CITY OF ALBUQUERQUE PLANNING DEPARTMENT HYDROLOGY DEVELOPMENT SECTION

DEVELOPMENT REVIEW BOARD--SPEED MEMO

DRB CASE NO/PROJECT NO: 1006926

RE: Lots 27 & 28, Block 3, Sunshine Addition/sketch

LOT 26-A & 27-B, BLOCK 3 SUNSHINE ADDITION

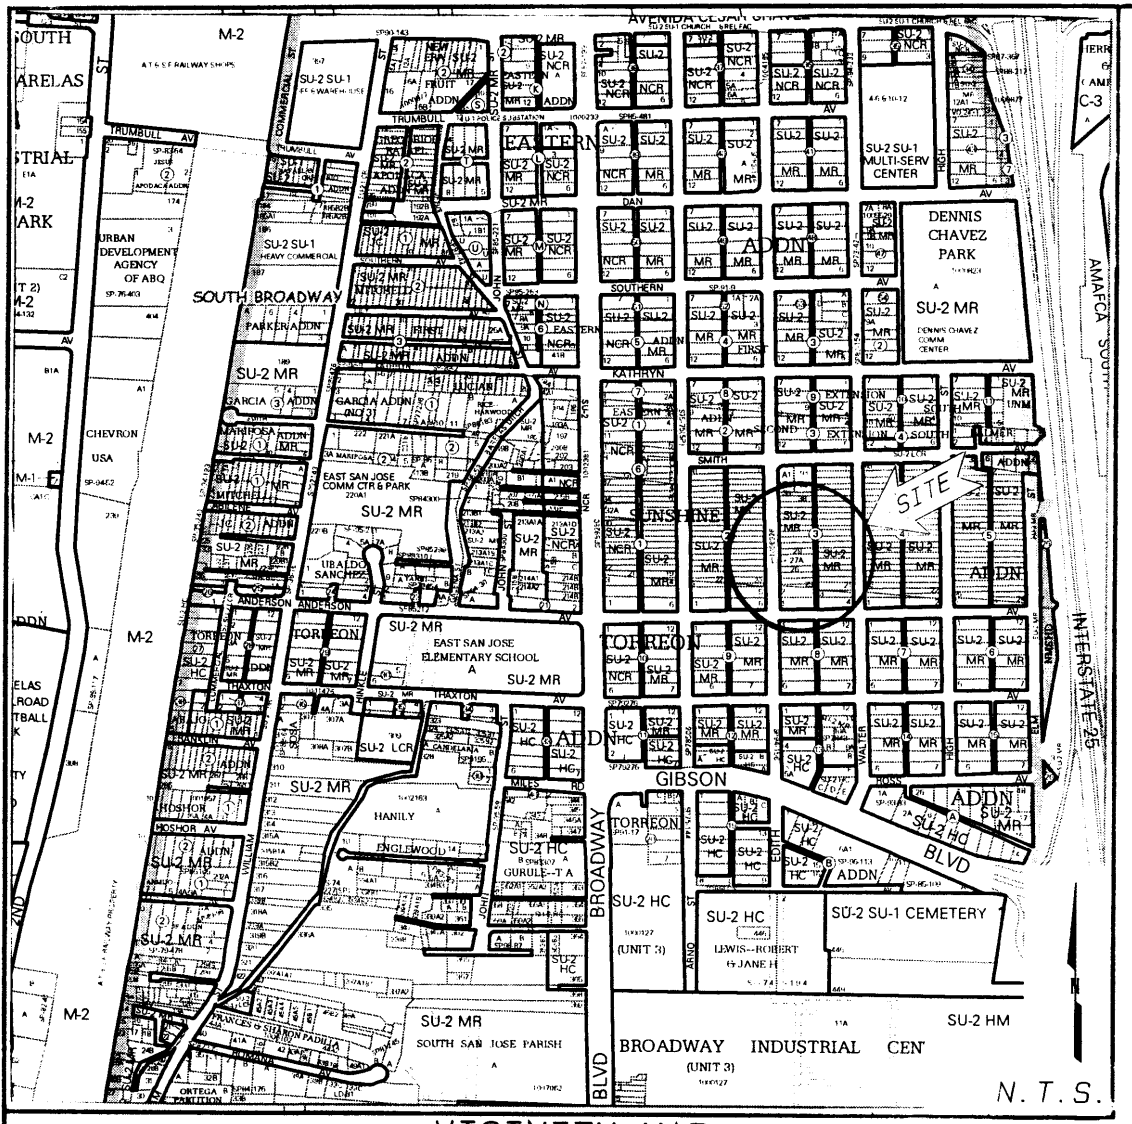
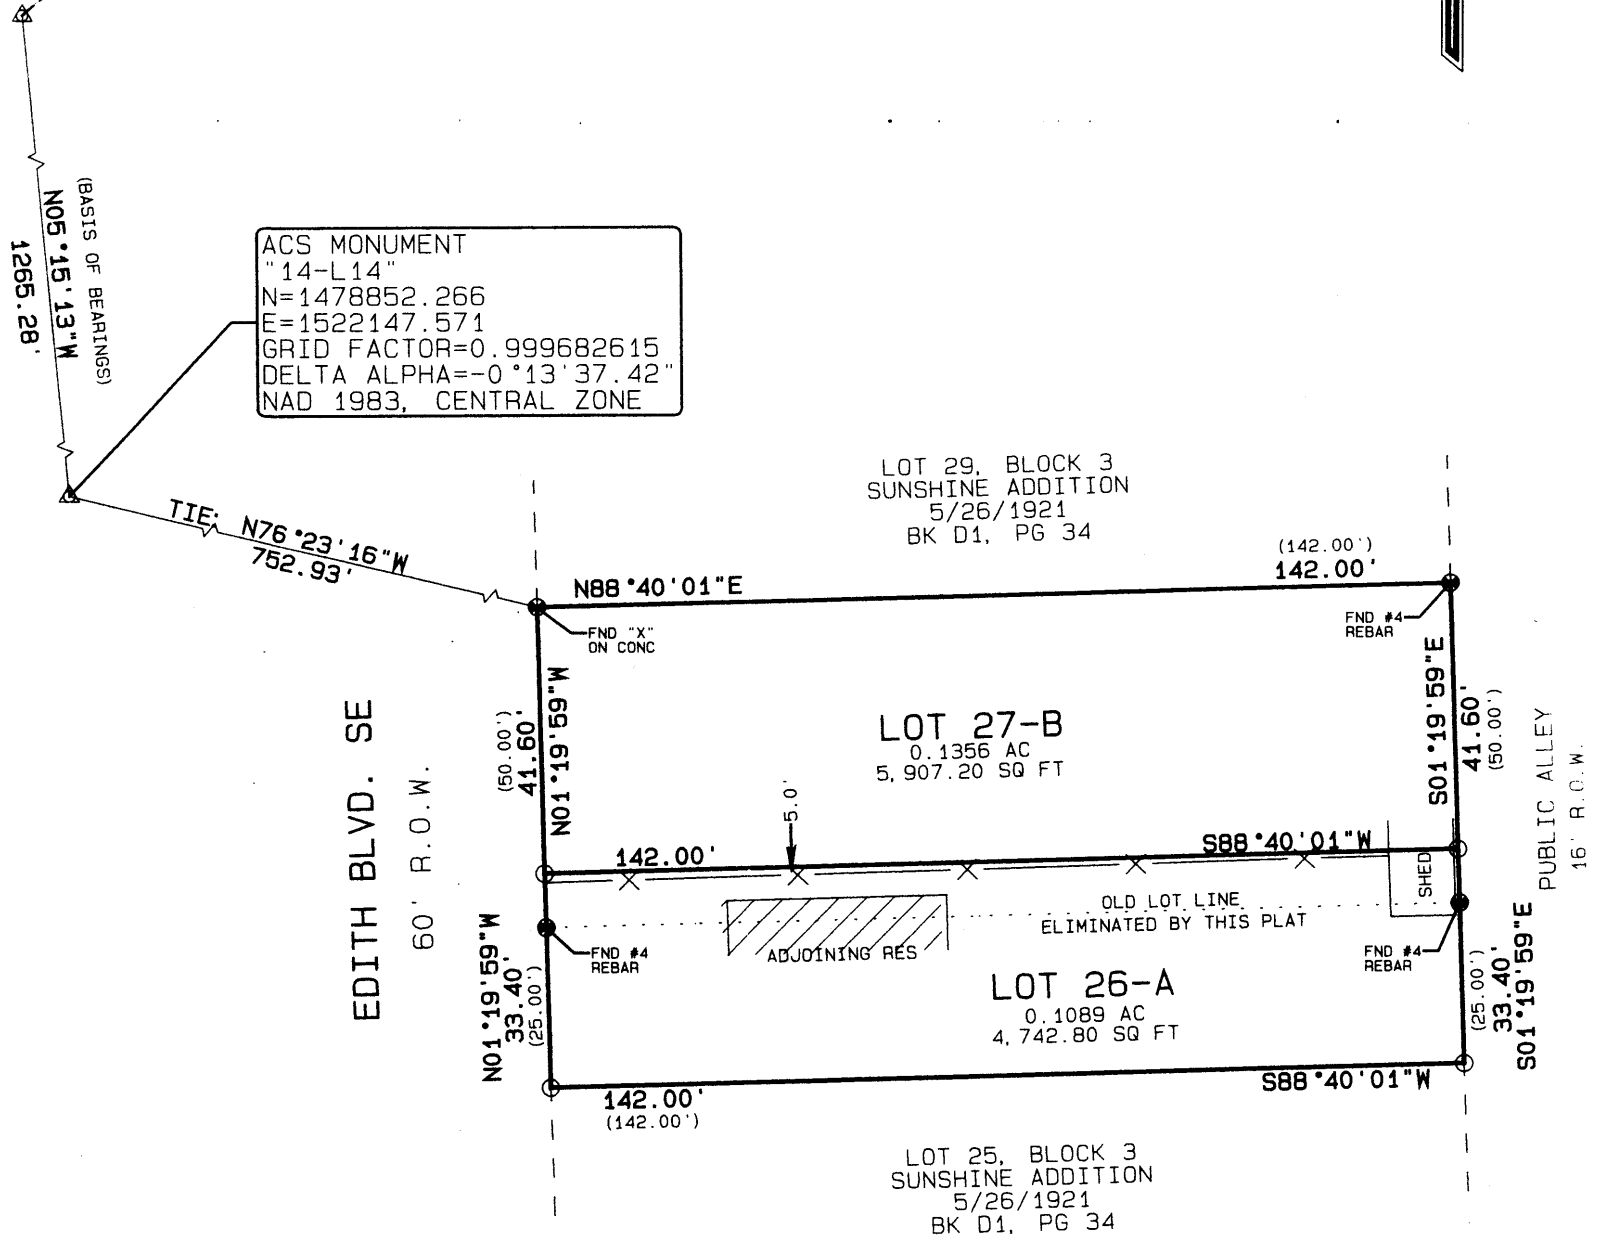
A full site sketch is needed for both lots. The setback on the south side of the residence on Lot 27-A in particular needs to be noted. It appears an easement is needed for the overhead powerline that crosses Lot 27-A (and Lot 26?).

LOT 27-A, BLOCK 3 SUNSHINE ADDITION

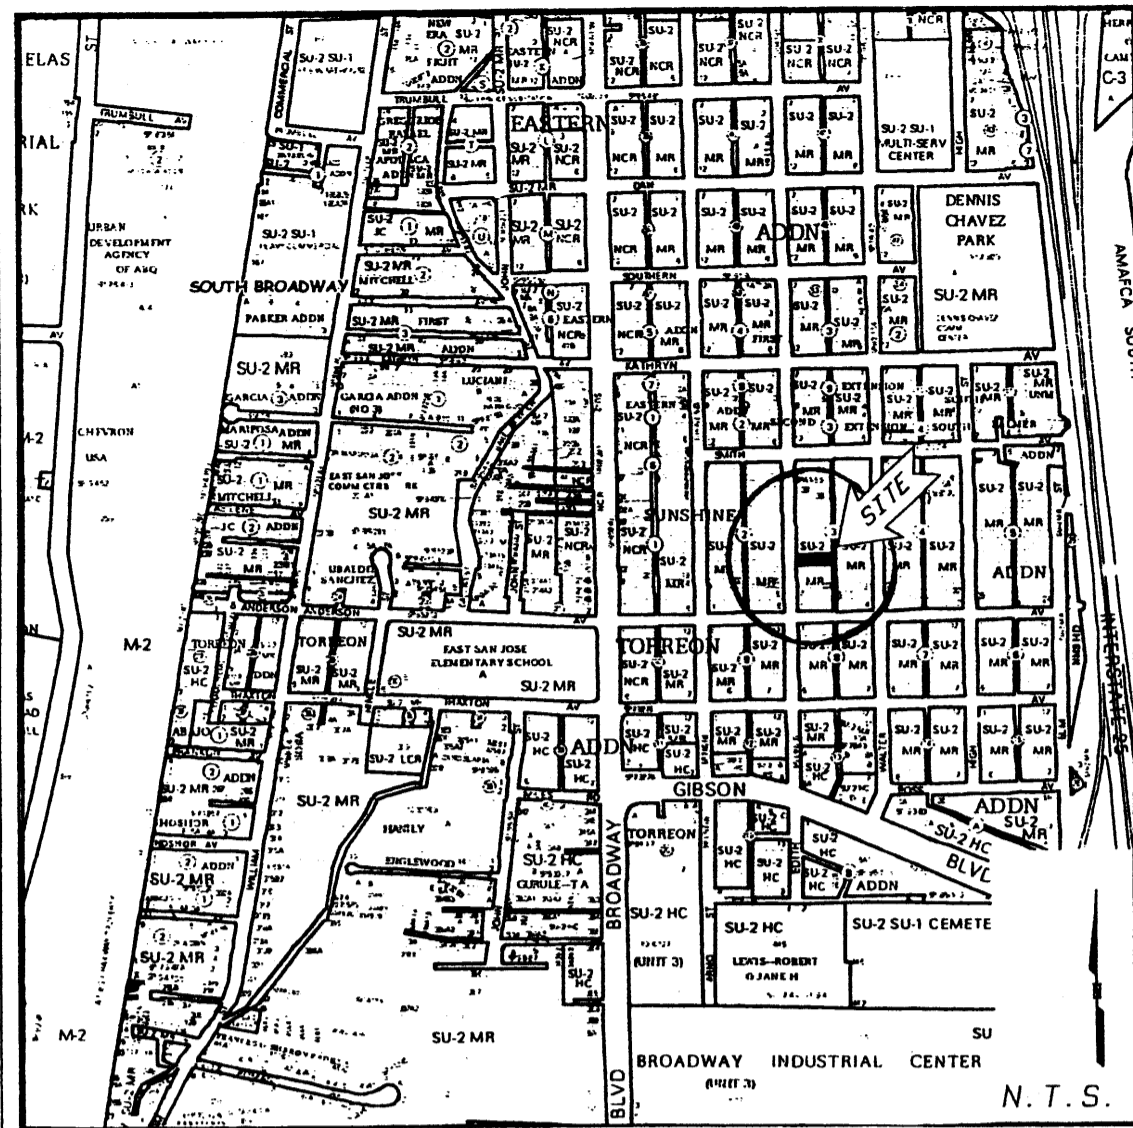
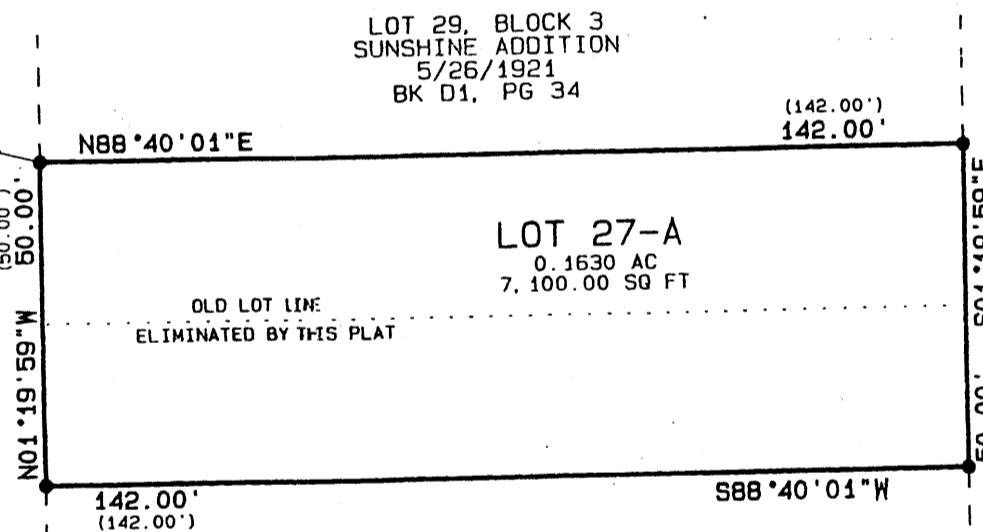
A Subdivision Note consistent with Section 14-14-4-7 (B) of the Subdivision Ordinance regarding solar collectors is required.

AGIS dxf approval is needed.
